WEST SUSSEX COUNTY COUNCIL CONSULTATION

TO:	Arun District Council FAO: Anita Gardener
FROM:	WSCC - Highways Authority
DATE:	4 November 2021
LOCATION:	Land to the rear of Bairds Farm Shop Crookthorn Lane Littlehampton BN17 5SN
SUBJECT:	CM/46/21/PL Variation of conditions following grant of APP/C3810/W/19/3227274 (CM/16/18/PL) relating to Condition Nos 2 - approved plans, 3 - Construction & Environmental Management Plan, 4 - tree protection & retention, 5 surface water drainage and 9 - car parking.
DATE OF SITE VISIT:	n/a
RECOMMENDATION:	No Objection
S106 CONTRIBUTION TOTAL:	n/a

Proposed Site Plan

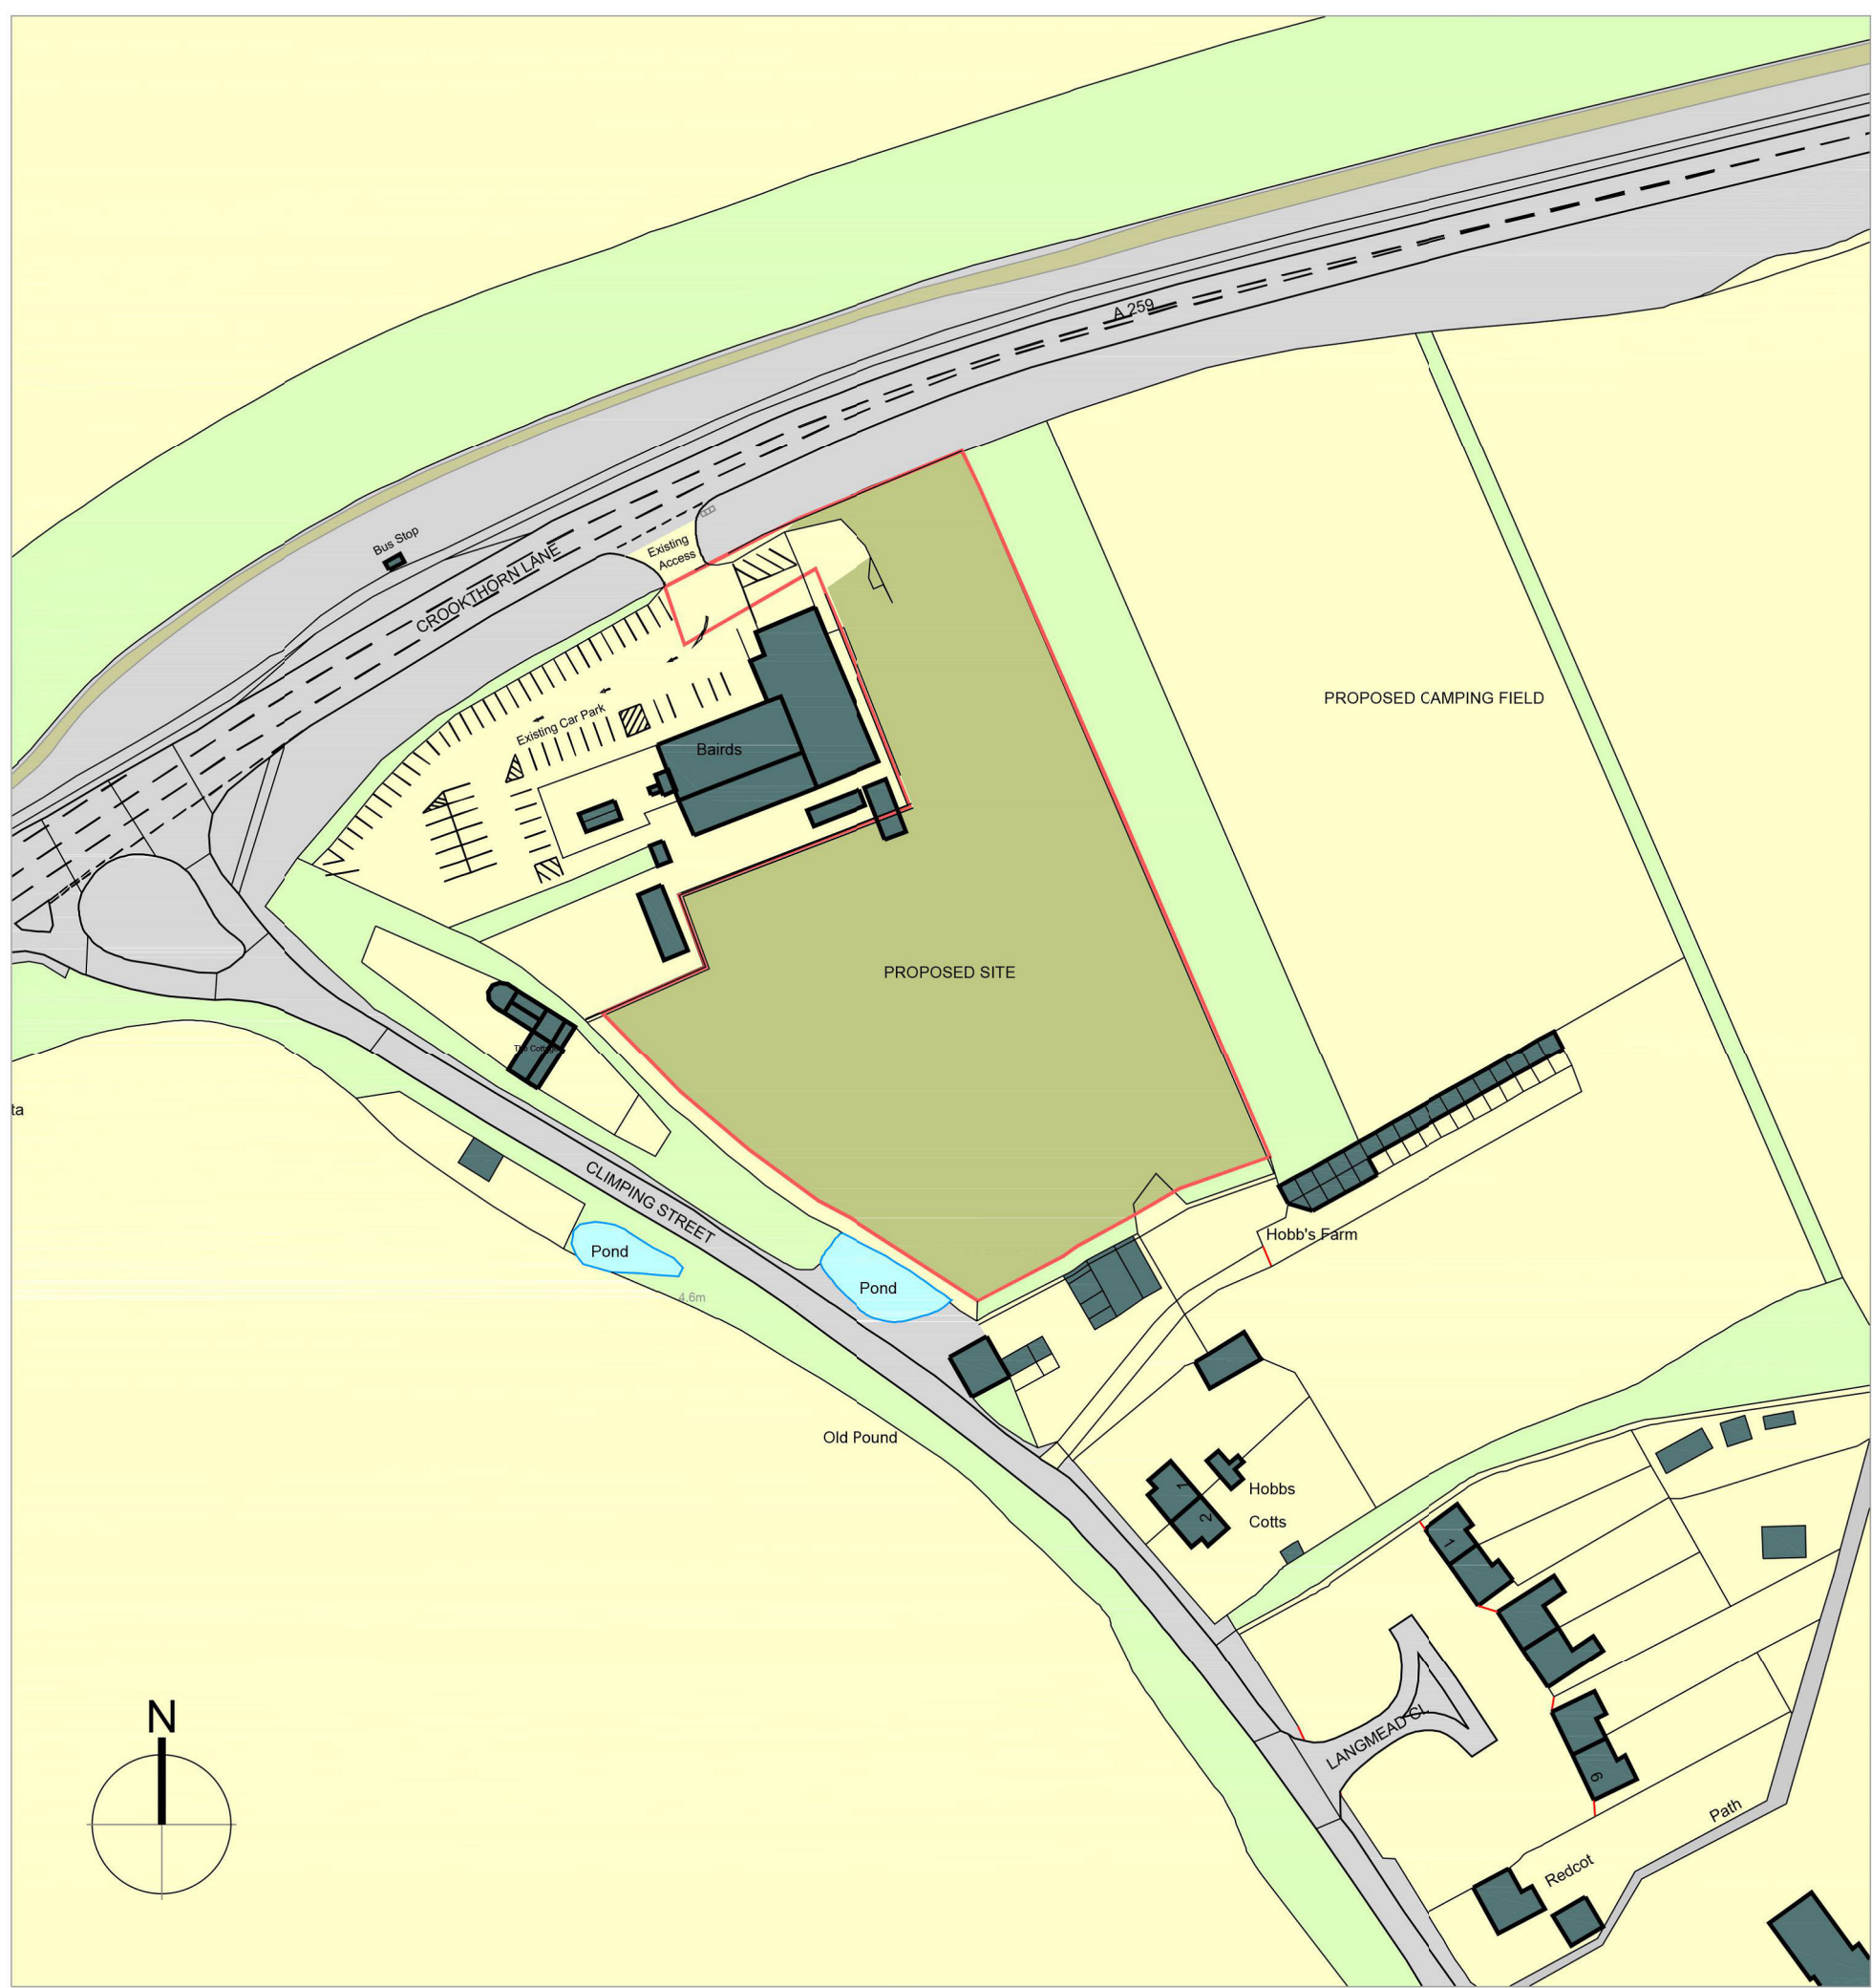
In relation to the car parking a total of 28 spaces (4 of which are dedicated for disabled people) are retained, as per the previously proposed number of car parking spaces under application CM/46/21/PL. The proposals are a minor reconfiguration of the parking layout which the Highway Authority has no objections to.
